Our Ref: P/68/20/NMA

Non-material amendment following grant of reference P/70/19/RES to change the Public Open Space lighting from mains fed lighting columns / bollards to solar powered lighting columns / bollards
Land To North And South Of Summer Lane Pagham PO21 4NG

Technical reference:
2020056

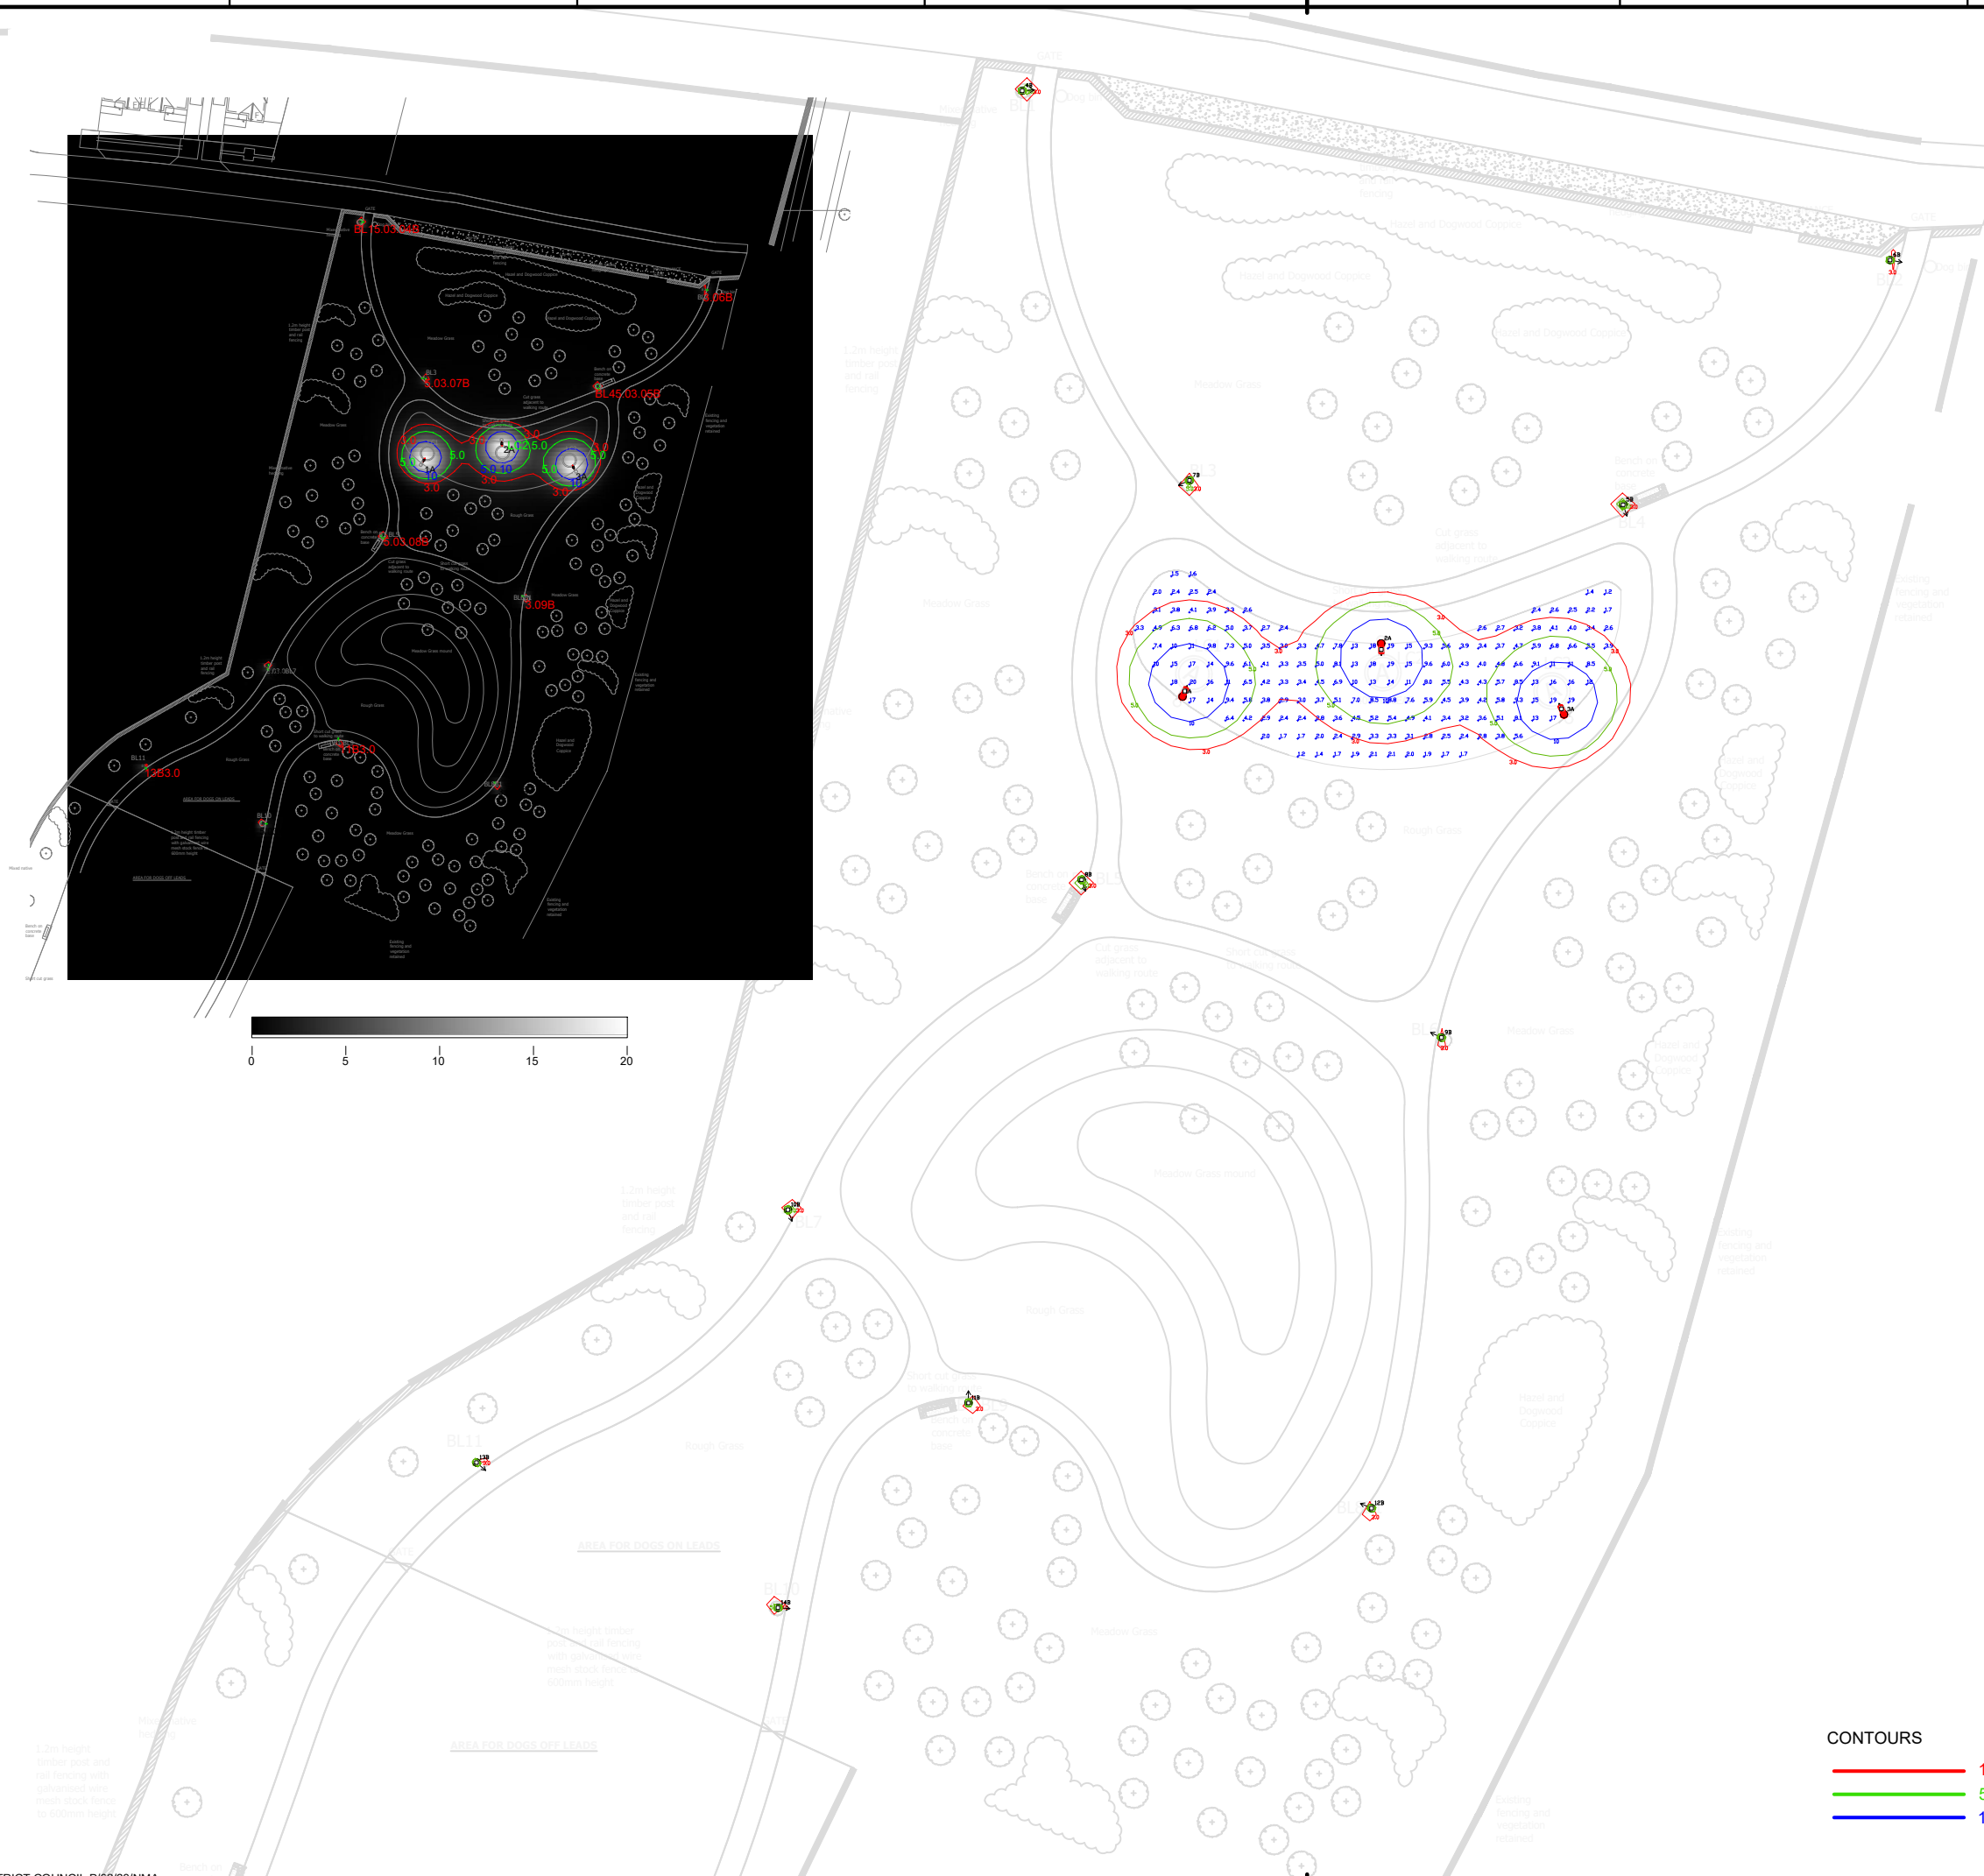
I refer to your recent application for a Non Material Minor Amendment. I note that you propose to change the power source for the bollard and column lighting in the Public Open Space switching from mains electricity to solar power.

Please note that the drawing "Prolectric Lighting Design" ref 2020056 Rev B replaces the originally approved "Proposed Lighting Layout" ref 100046.PRIV.1300.1301 Rev P01 and the "Outdoor Lighting Report" 1000090.POS.001 Rev A. This NMA does not affect the lighting approved on the residential part of the site area.
